Subject: BR/93/18/PL

Title
New Container Store to
replace existing garage

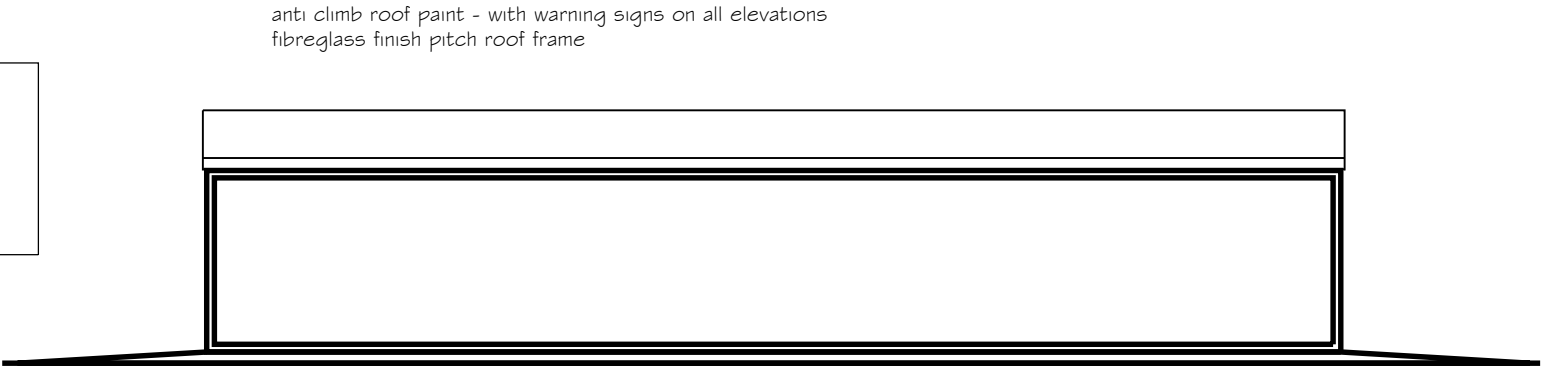
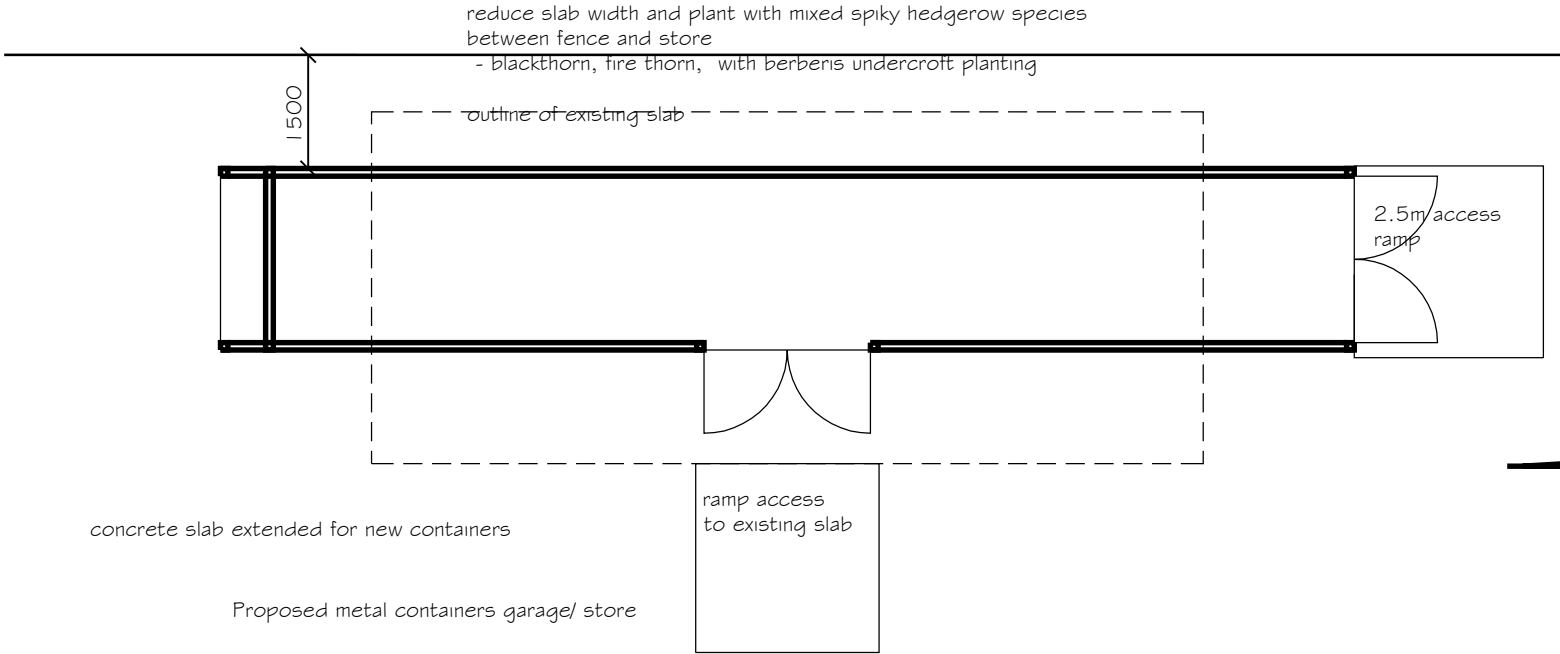
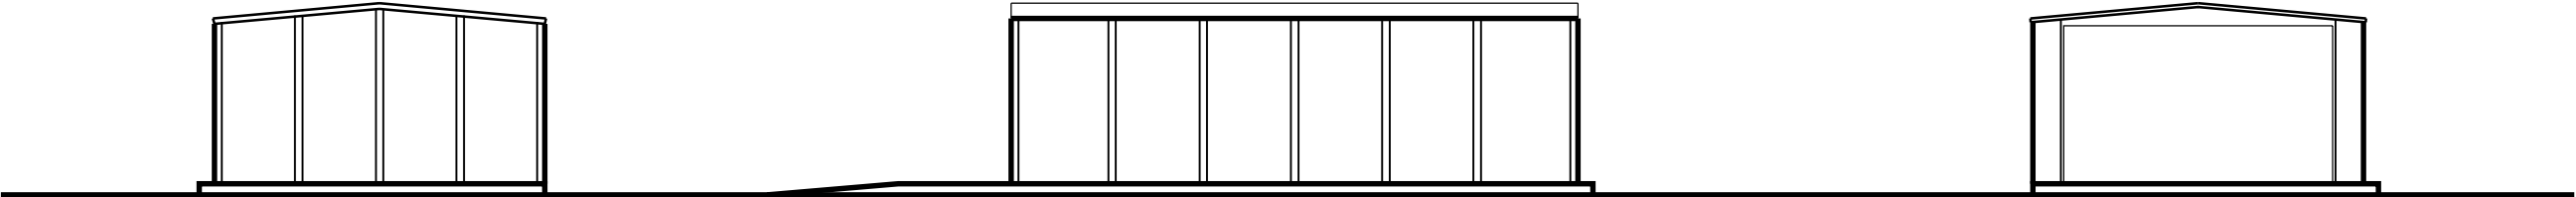
We have looked at the containers which are situated in the rugby carpark at the moment, not only are they massive but also very ugly to look at, is there any way that this gets considered before any decision is made? I think anybody that sees what they look like would agree with us.

Looking at the proposed plans, it looks like they will block our back gate and be to close to rear fence, I'm sure there are more options available to site them where they would not be a nuisance to anyone, hopefully you can help us before this gets the ok.
